ASSESSMENT REPORT

SENIORS LIVING DEVELOPMENT 34-36 MEMORIAL AVENUE, KELLYVILLE MP 09_0180 (MOD 7)

11527
Site Plan Basement - DDA option
1:400B A1
December 2017

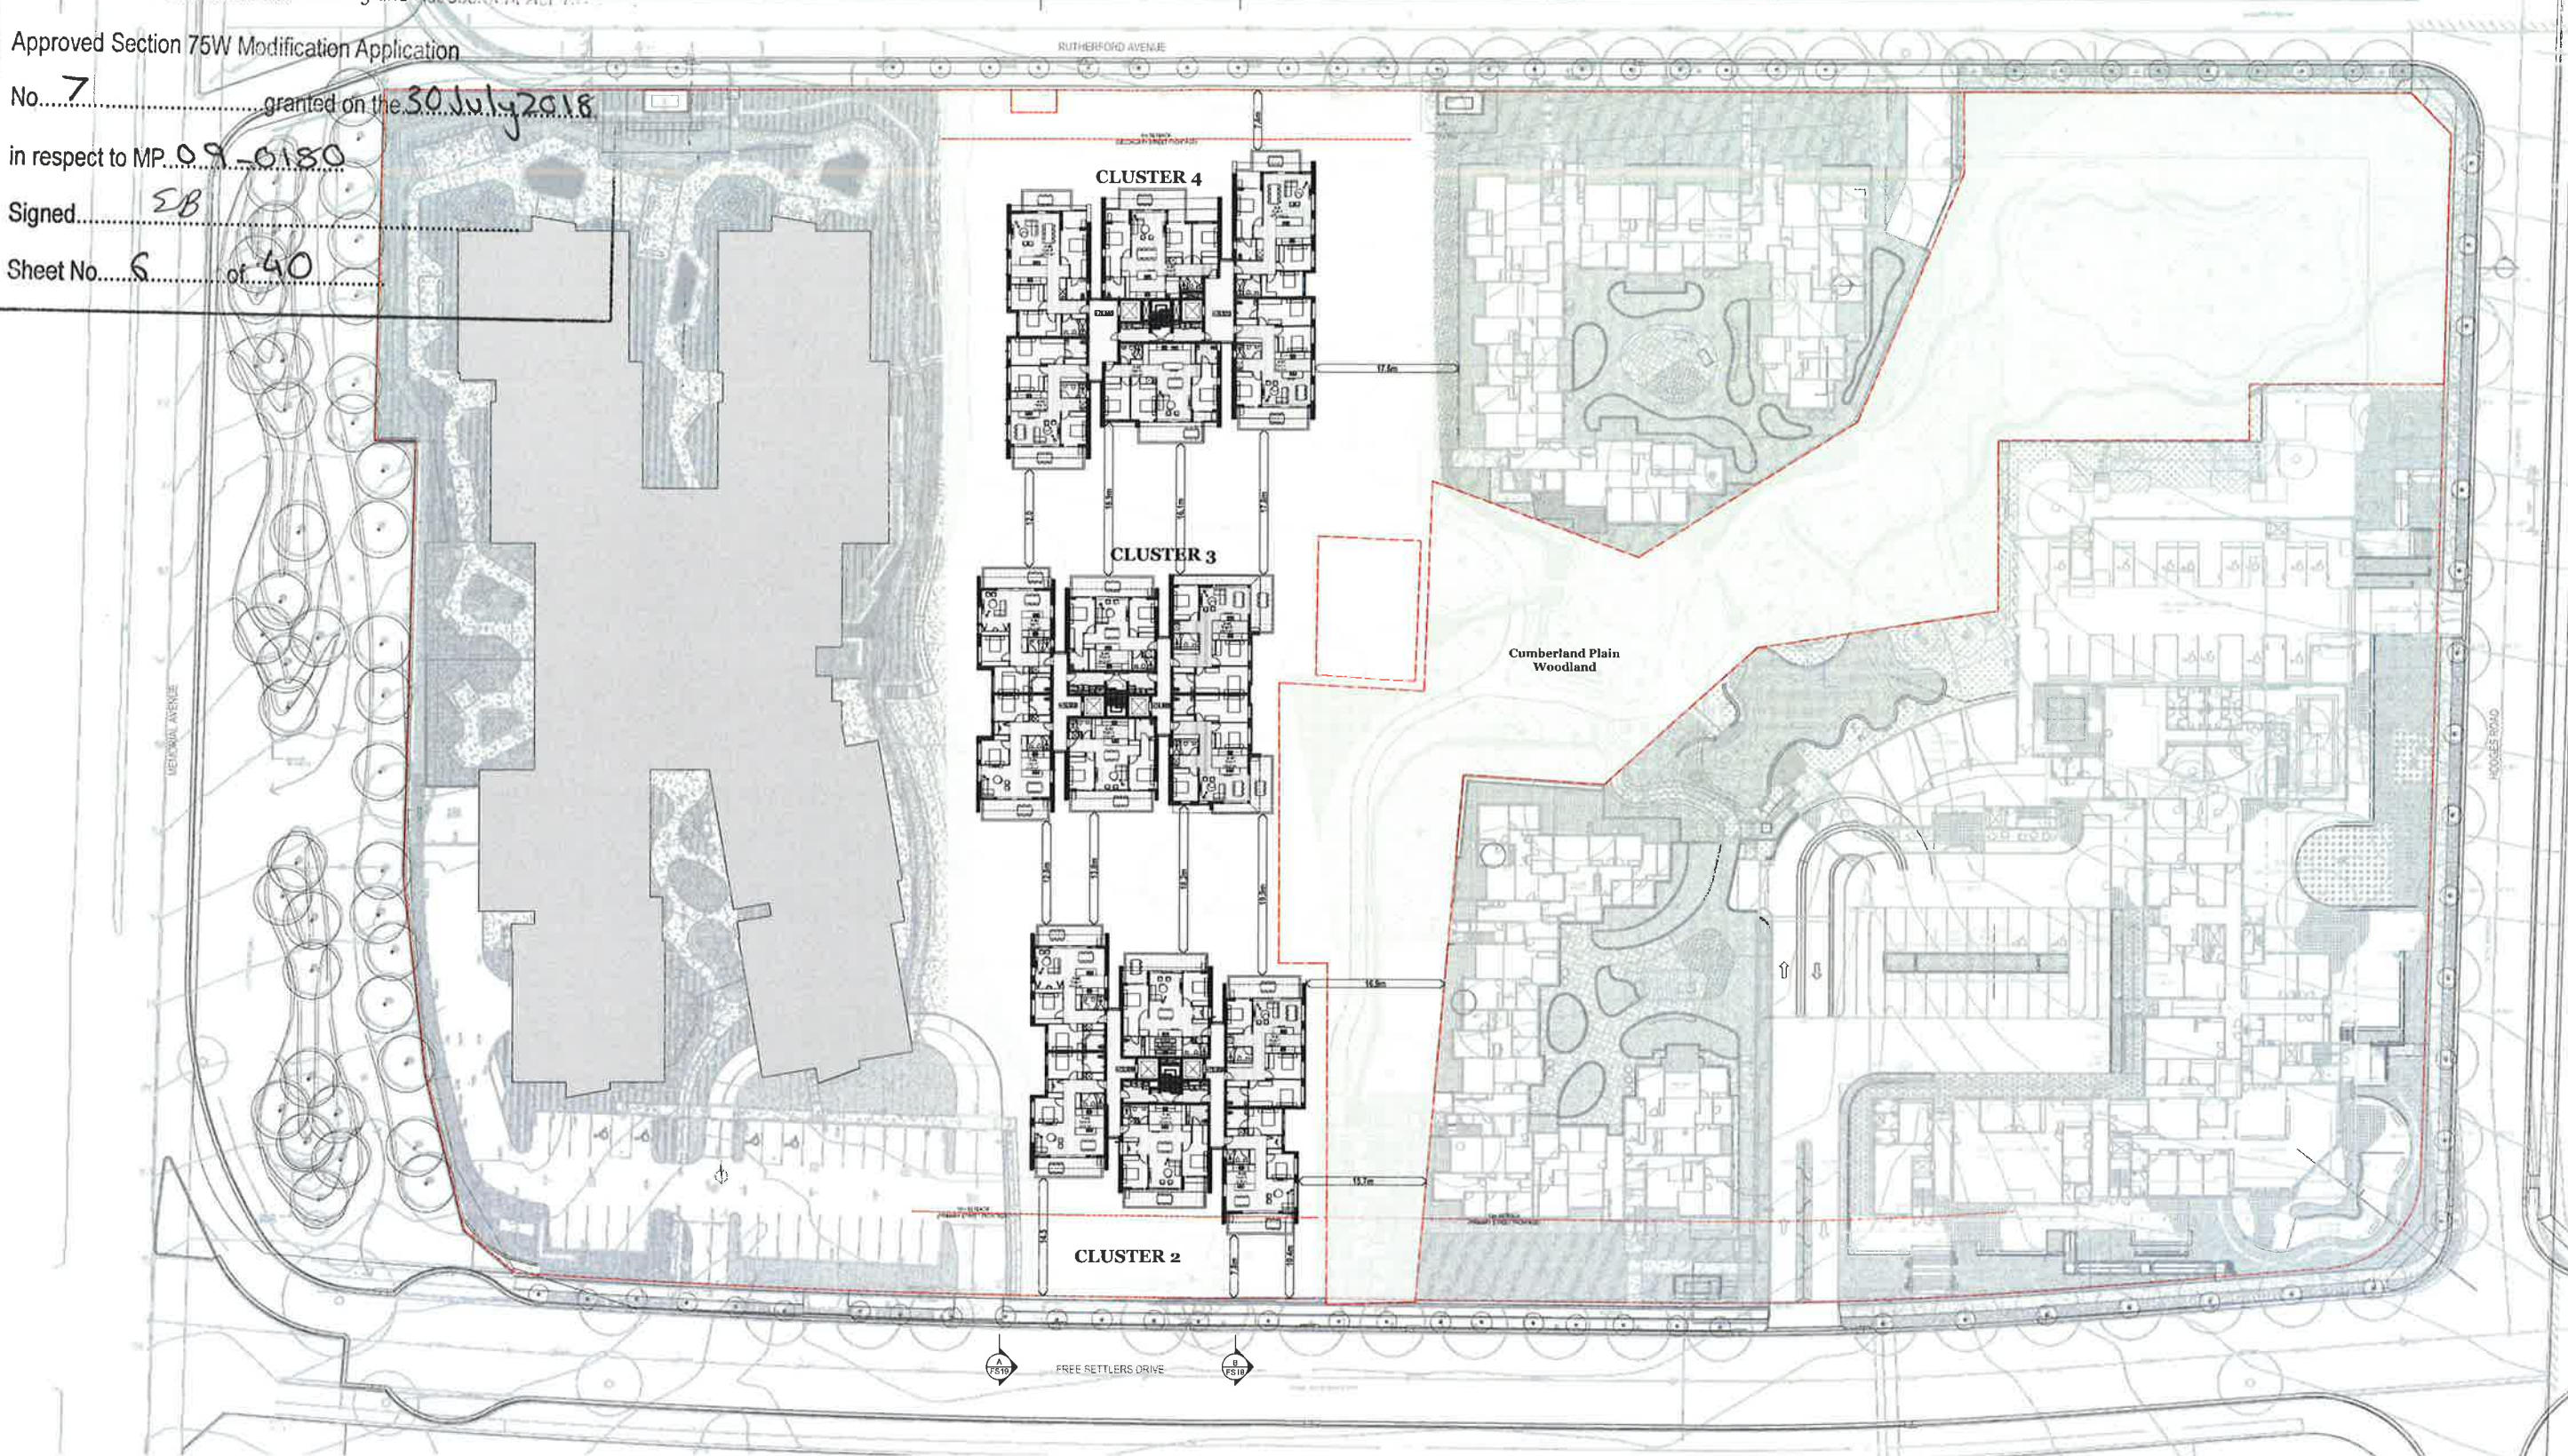
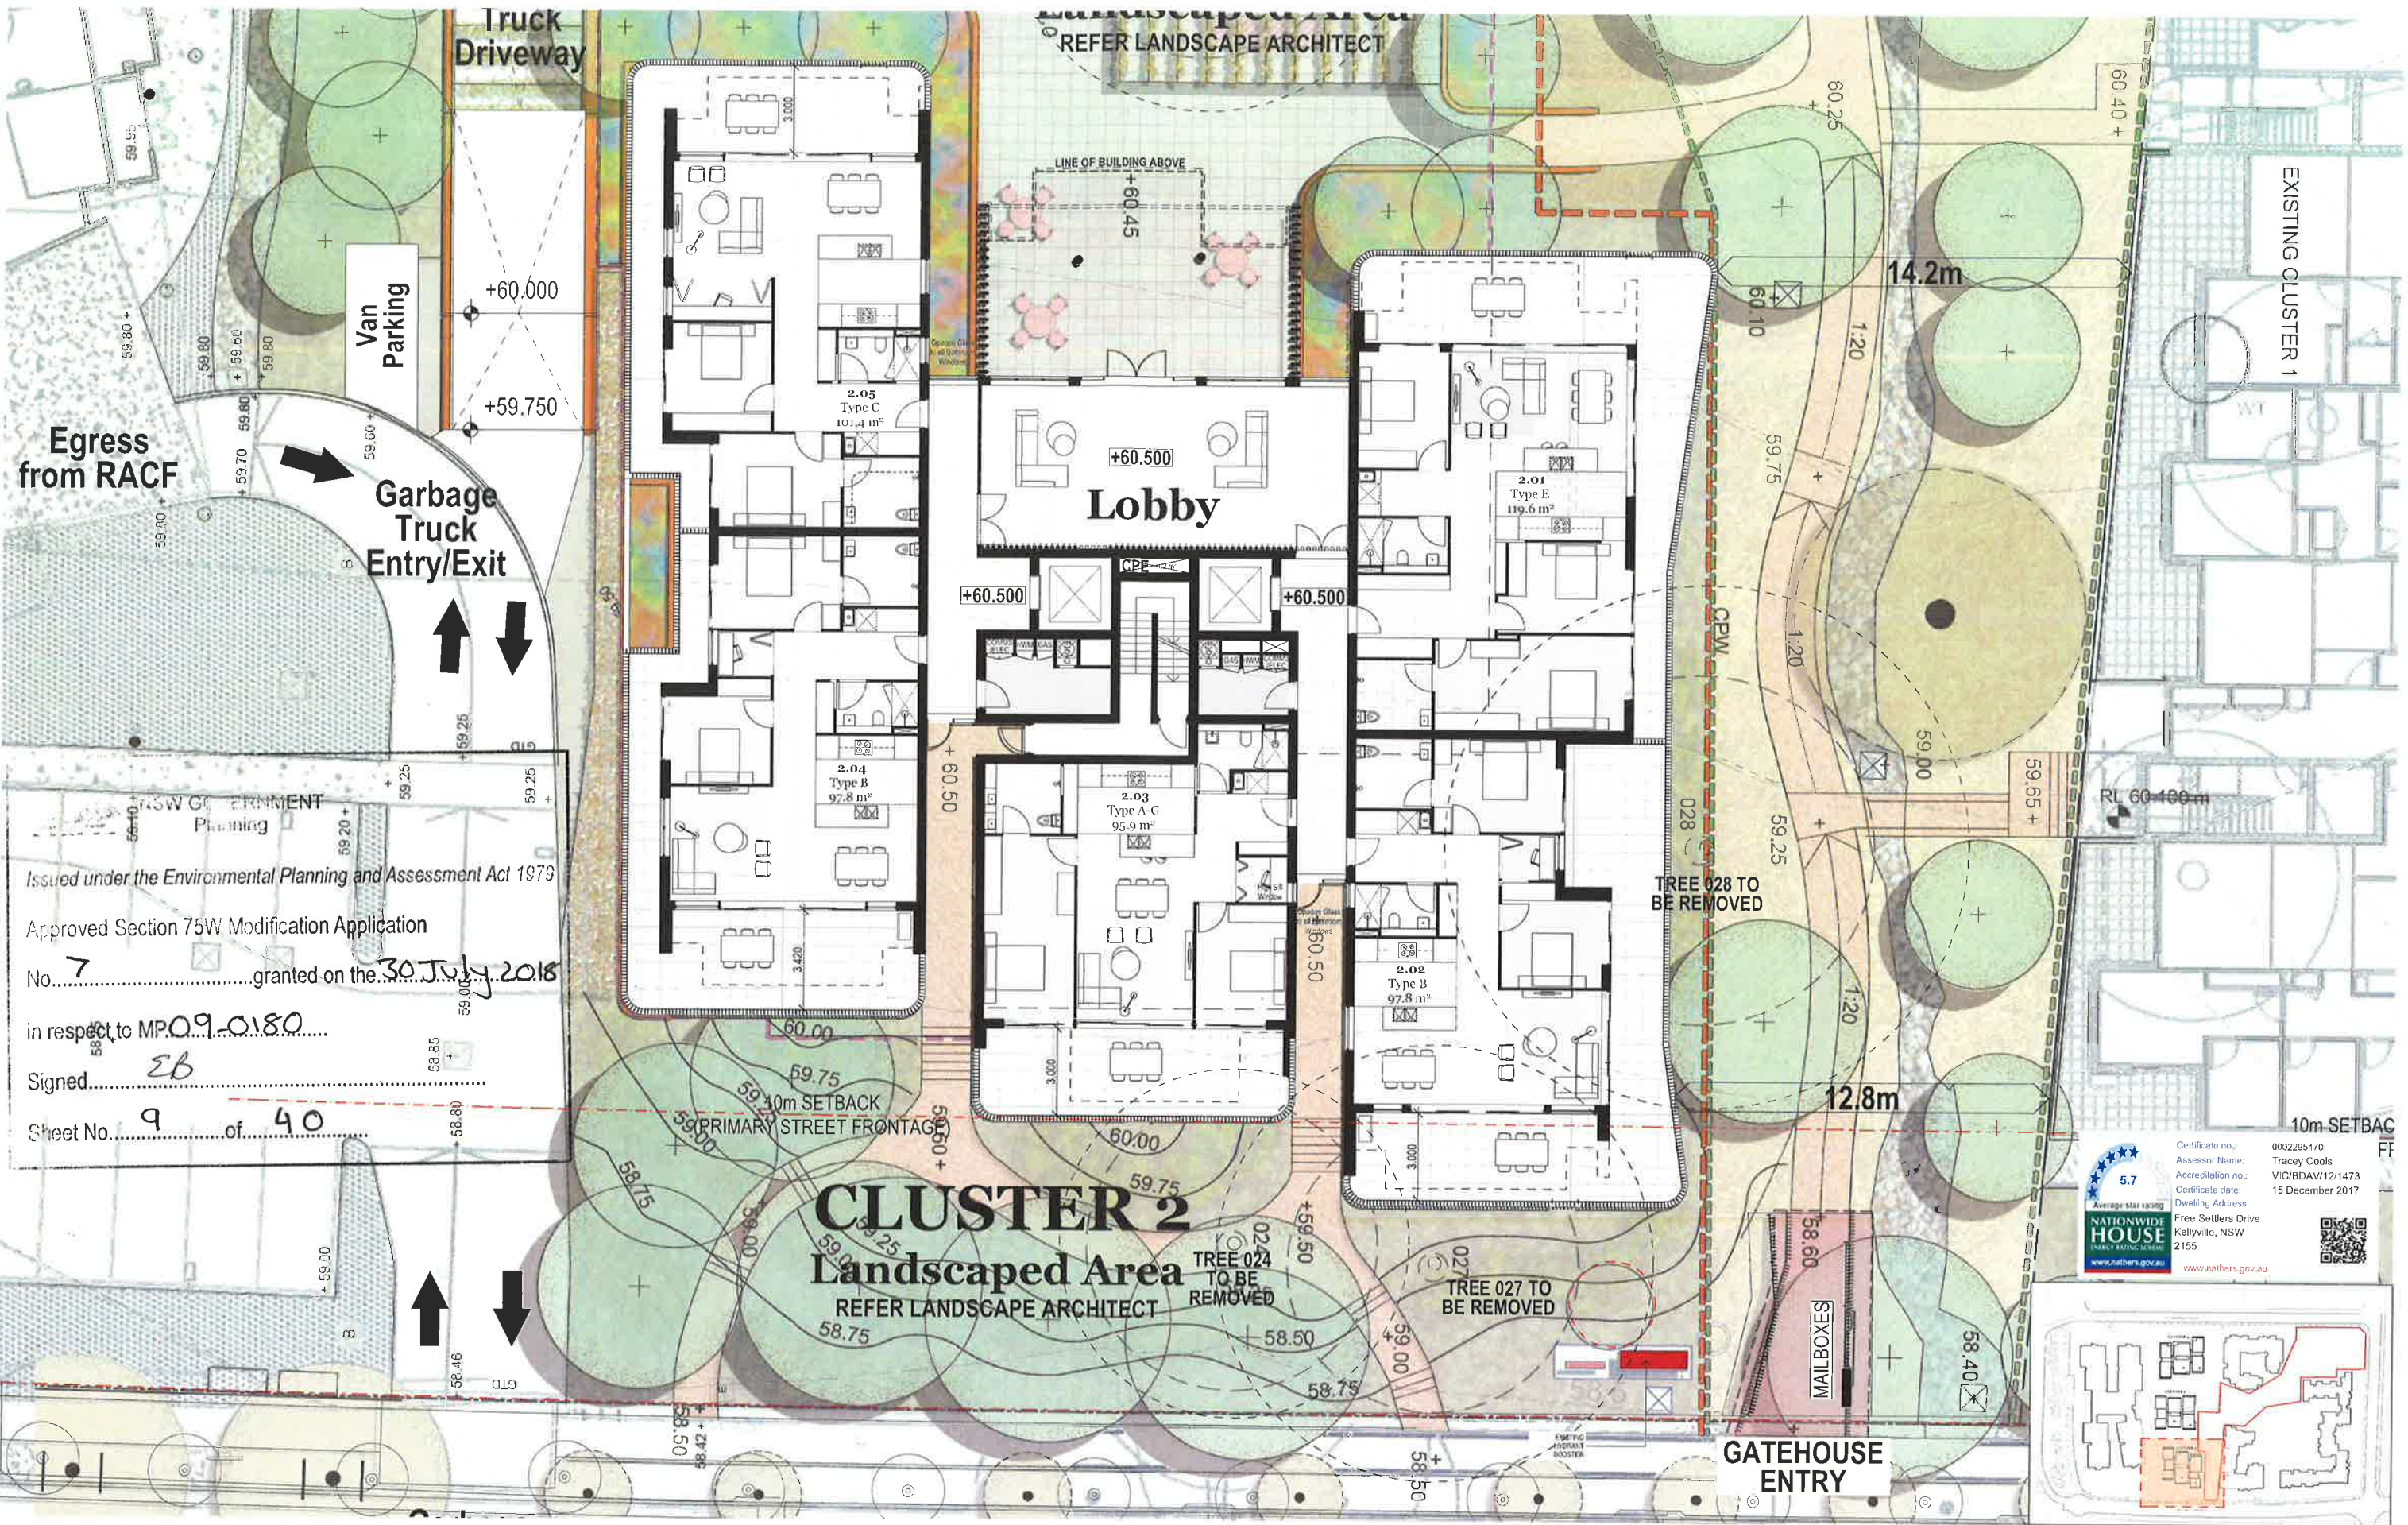
- further information is needed to demonstrate basement ramp headroom
- amendments to the parking design are required to remove or relocate shutters, to provide appropriate turning room, and locate disabled spaces near lifts

- Option 1: 126 spaces including 7 accessible spaces 3.8 m in width or
- Option 2: 122 spaces including 4 accessible spaces 3.8 m in width and 17 accessible spaces 2.4 m in width with an adjacent shared space.

The Department considers Option 1 represents a significant reduction in accessible parking, with no parking spaces provided in accordance with AS2890, compared with over 20% as approved. The Department considers this option is inconsistent with the intention of the SEPP and is therefore unacceptable.

Option 2 provides a much greater level of accessible parking. Although it includes less accessible spaces than the approved development, the Department considers that subject to one additional space being provided in accordance with AS 2890, the number of accessible spaces would be sufficient in this case.

As discussed below, the Proponent is only required to provide 18 parking spaces in total to service the residents of Clusters 2, 3, and 4. Therefore, provided all of the 18 required spaces under the SEPP are designed to comply with AS2890, the Department considers the intension of the SEPP would be met. Given the proposal only includes 17 accessible spaces, which comply with AS2890, the Department has recommended a condition requiring one additional accessible space to be provided.
